## URBAN DESIGN COMMENTS

Site Address: Beaches Yard, Horton Road

Planning ref: 75221/APP/2022/2968

*Proposal: Redevelopment of the site to provide a flexible warehouse facility (Use Class B2/B8) and ancillary office space, with associated HGV loading and servicing bay, car and cycle parking, access arrangements, landscaping and infrastructure.*

Rev	Date	Description	By	NW	Project Beaches Yard	Project description Warehouse	Stage Planning	Job N 0203
	22/08/18	office shift			Title Proposed South & North Elevation	Scale 1:200@A1	Drawing No 102	Rev —

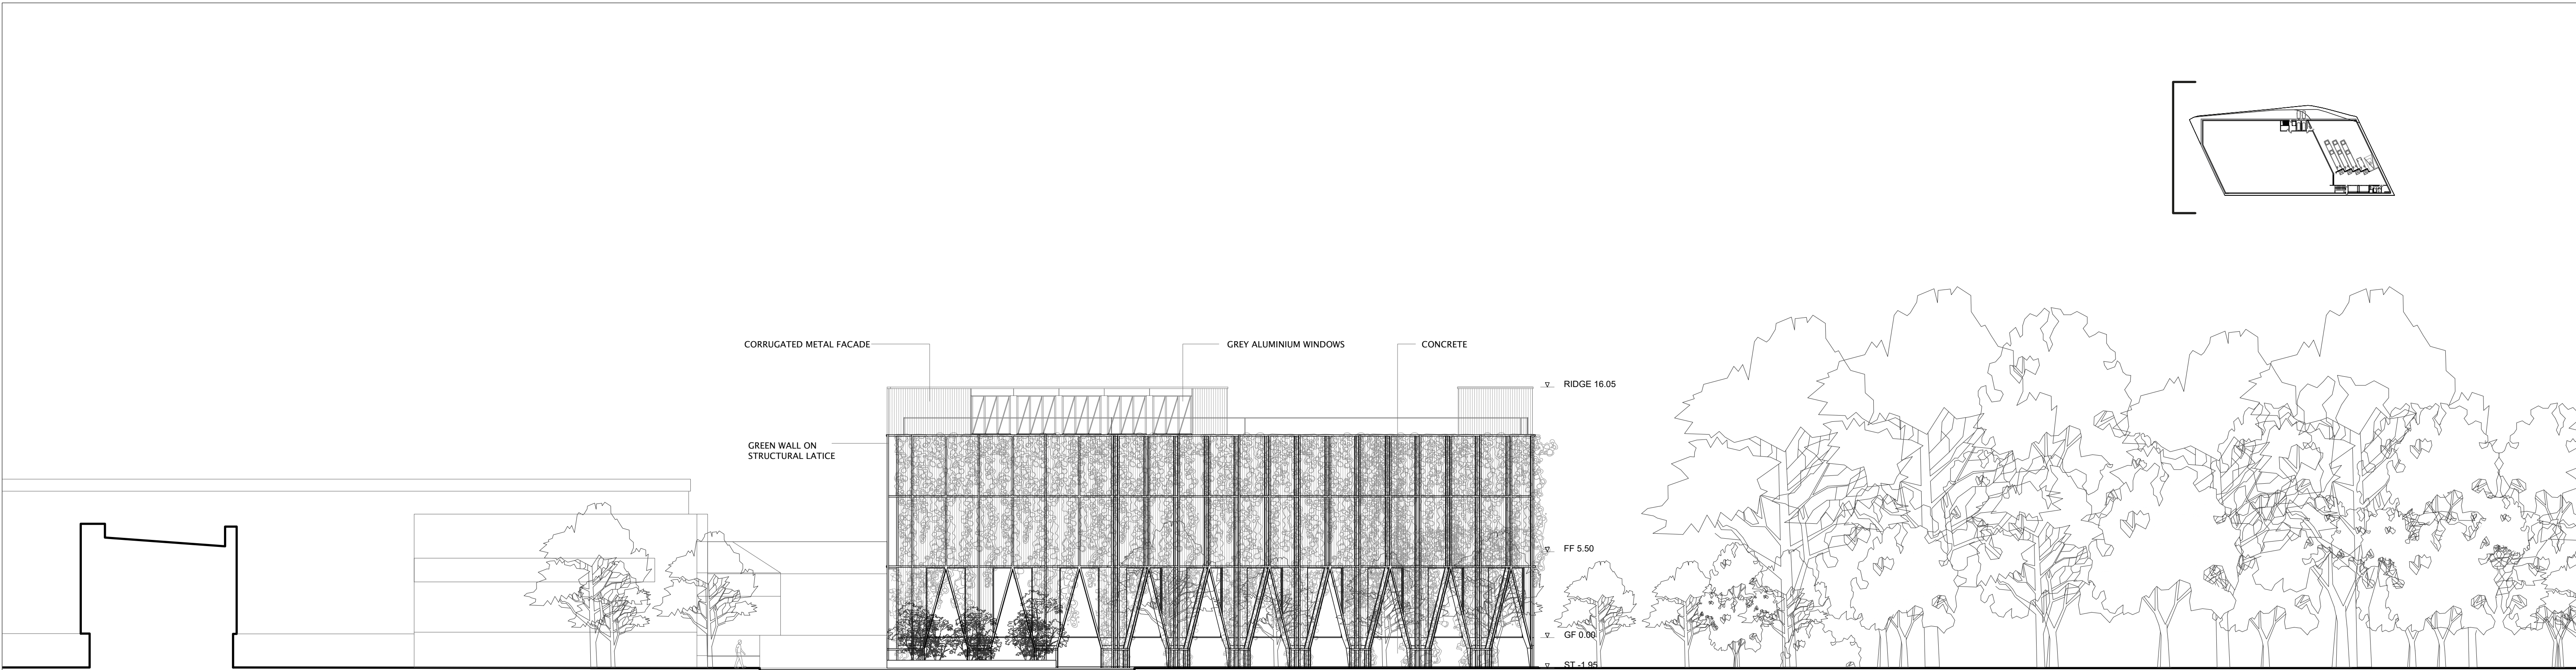
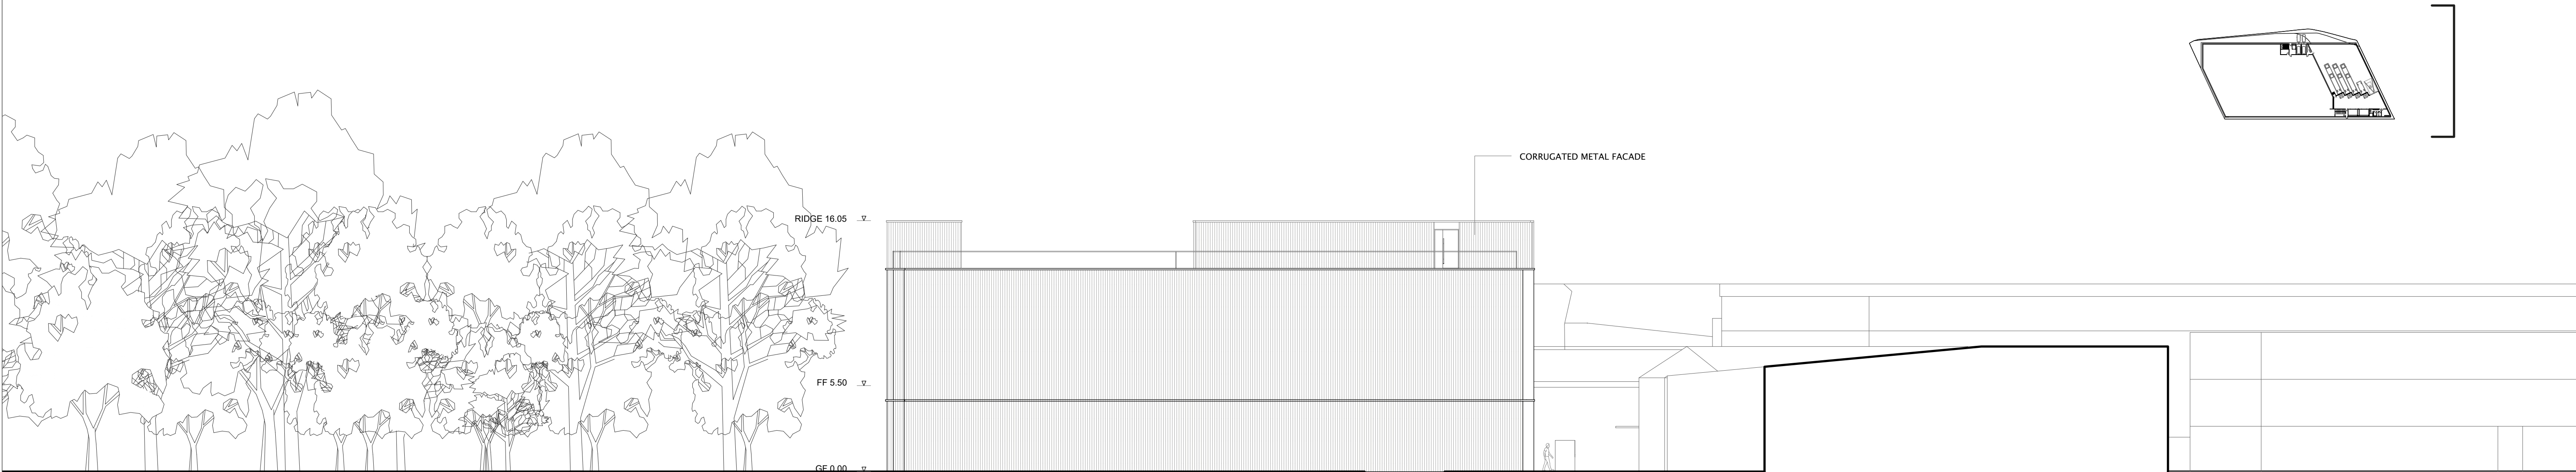
*“Revise the height of the building Plans and Elevations”*

*“Revised elevational treatment with more details on the green wall Plans and Elevations Information to explain the material for the climbing plants and materiality of the façade behind”.*

*“The height of the building is 18m, the highest within the industrial area to the west of which it forms a part. Broadly, this industrial area is made up of large single storey warehousing. It is acknowledged that there are marginally larger buildings to southeast. However, the reduction in height from the pre-app height of 21m is not considered enough to satisfy this issue”.*

*“A building of amplified height compared with the rest of the industrial estate”.*

*“on the edge of the Register Park and Green Belt is not an appropriate response to the context. The building should broadly reflect the prevailing height of the other buildings within the industrial estate of which it is part. The proposed height lacks a convincing justification”.*

We have addressed the proposed height of the building above. We see no clear justification in the planning balance to reduce the height of the building any further. The building has a maximum height of 16.5m which will ensure the building sits comfortably in the largely industrial setting.

We are unclear why this information is being requested now with detailed materials typically conditioned for major development. Notwithstanding, we have provided significant detail in relation to the proposed green wall within the submitted landscape proposals drawing prepared by Charnwood Landscape Design Limited. Should for whatever reason this drawing has not been reviewed, at this stage the scheme proposes a Jakob Green Wall trellis system. The system is fabricated from chromium-nickel austenitic stainless steel with low carbon content and contain molybdenum for excellent corrosion resistance. These systems are stainless steel, corrosion resistant, low maintenance, high tensile strength products provide design flexibility, durability, high strength-to-weight ratio, functionality, and impressive aesthetics.

- Distance from wall: 200mm
- Climbing Pattern: Vines
- System support maximum growth height: 20m
- Technical data: <https://jakob.co.uk/wp-content/uploads/Green-Solutions-G2-Technical.pdf> Page 19
- The materiality of the façade behind is the same as the other elevations.

This comment is again factually incorrect. The proposed building has a height of 16.5m at the highest point. Notwithstanding, the comment reads as though the proposed warehouse would sit in isolation with no other tall buildings in the area by separating the industrial area into two sections, the west and southeast where the Design Officer accepts there are ‘larger’ buildings. This is a wholly incorrect way to assess the character of the area. Firstly, all Prologis warehouses are **inside** the green belt, all the roads around the warehouses are also within the green belt. Secondly the warehouses are in excess of 20m in height. It is noted that the warehouses to the west of our site are 11-15 meters in height, however, this is only marginally lower than the proposed building.

See above. While the proposal seeks to maximise the site in accordance with policy, the building is not of an amplified height and shall sit comfortably within the existing context.

Rev	Date	Description	By	NW	Project Beaches Yard	Project description Warehouse	Stage Planning	Job N 0203
					Title Proposed West & East Elevation	Scale 1:200@A1	Drawing No 101	Rev —

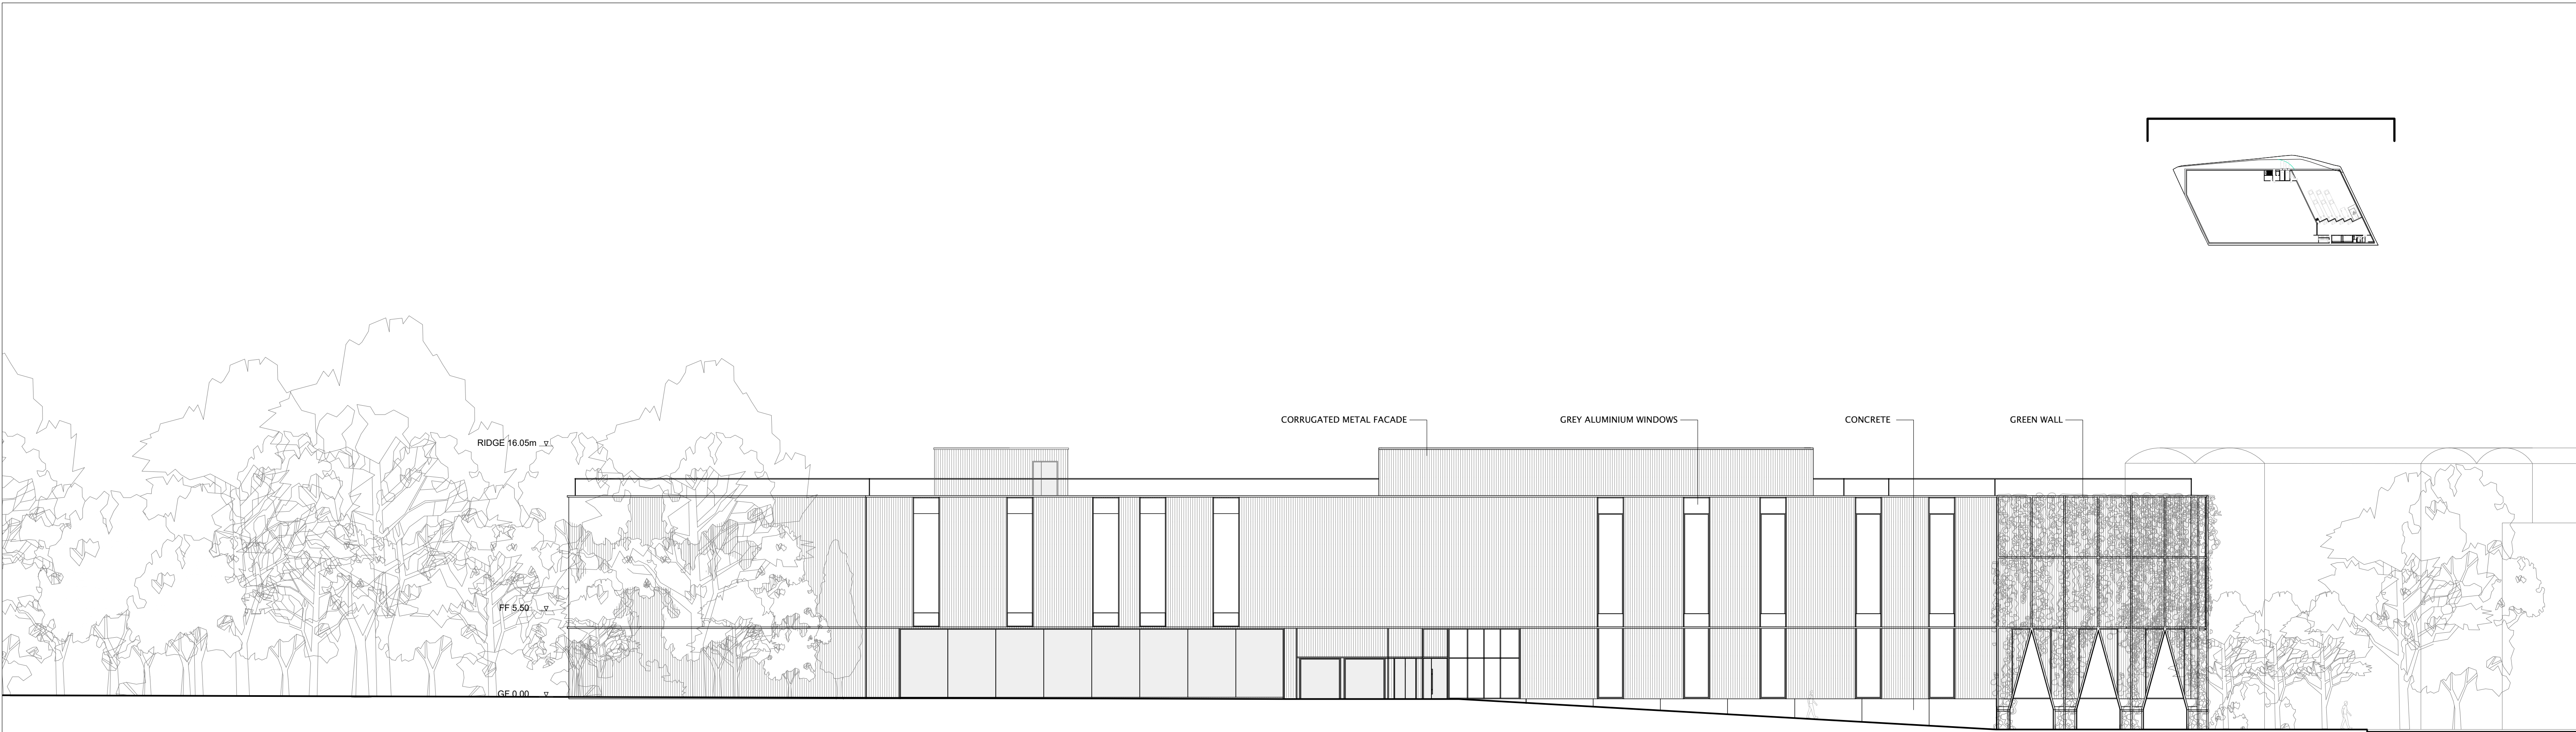
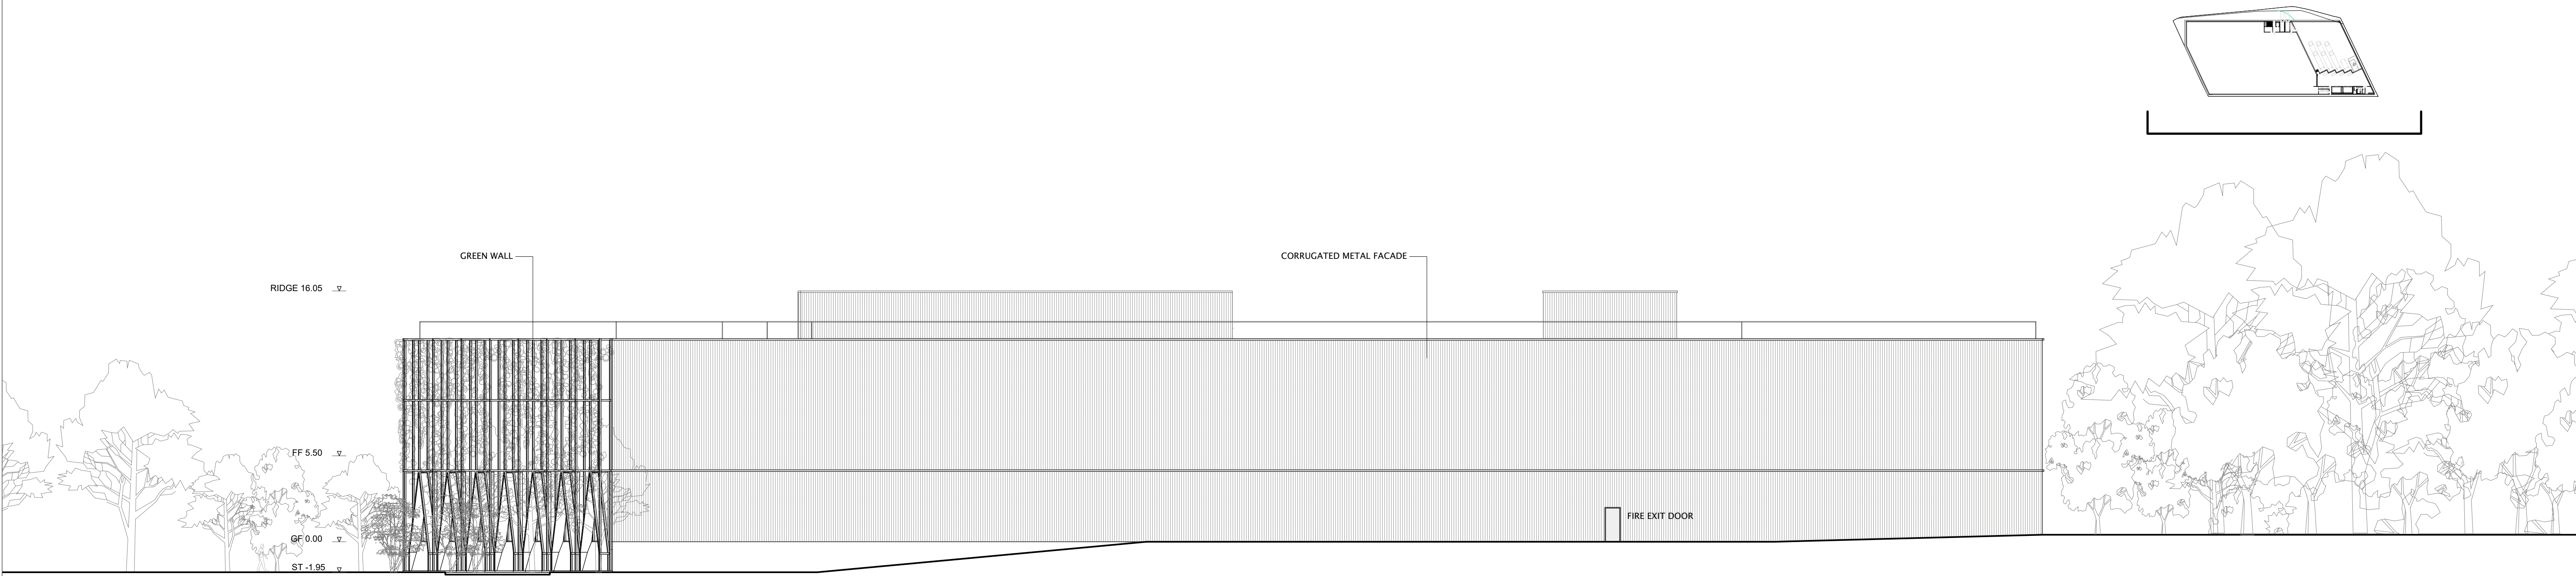
*“The pedestrian entrance to the building is currently proposed along the building’s western façade which involves pedestrians crossing the vehicle entrance to the lower ground floor car park. This entrance location should be revised to accommodate the pedestrian entrance from the higher*

*quality green wall façade along the Horton Road active frontage. This would deliver a more direct route for pedestrians with better legibility and overcome the issue of pedestrian crossing the vehicular entrance to the building”.*

*“Removing the entrance from the western façade has the added advantage of allowing the long windows that create the distinctive western elevation to only interrupted by the vehicular entrance”.*

*“The entrances currently fail to align with the long narrow windows along the west elevation which disturbs the clarity of the design rational for this elevation”.*

*“This approach echoes the linear windows along the other western façade and limits the area for the climbing plants which are unlikely to colonise the extent shown”.*

*“More information is required to explain the material the climbers will be trained on and the materiality of the façade behind”.*

1. At the proposed office level, the scheme needs to provide a passage that leads to the office which is reflected by the proposed elevation drawings (west, east and south) making the warehouse appear taller on these drawings.

2. Providing an entrance to the Horton Road frontage is not practical as a ramp to the entrance is required for accessibility purposes. The proposal requires a drop of 600mm to enter the basement and this entails a ramp of 7.2m in length.

3. The proposal would subsequently lose an alternative fire exit along the private road.
4. The proposal would lose valuable soft landscaping to the Horton Road frontage to allow for a new entrance at the corner.

5. The elevation along Horton Road will need to be amended to show the elevator reaching the top floor office floor (plus the elevator overhead), making our scheme appear even taller.

There are no safety concerns in regard to pedestrians crossing a car park entrance, it is a common feature in new development. To ensure safety, the proposal includes new bollards to make sure there is a strong demarcation between the car park entrance and the crossing of the pedestrians including clearly visible signage. This recommendation should be reconsidered.

The proposed location of the windows are specifically designed to follow the latest in building energy efficiency regulations and is commonly the commercial preference for warehouse operators. This is an industrial building not a public shopping centre and it should be designed accordingly. Also, the submitted design is strongly encouraged to follow the design criteria and features in the strategic industrial area as it need to be in keeping with the area and thus in keeping with current policy of the Council.

The applicant can accept an appropriately worded condition to align the widows with the desired location of the entrance.

Our Landscape architect and many landscape architectural articles indicate that the types of ivy's, will grow up to 30 meters. The green wall is only 12 meters tall.

There are many options to fasten the ivy's for the climb, please see above suggested fastening detail, which is to be agreed as part of the build works.
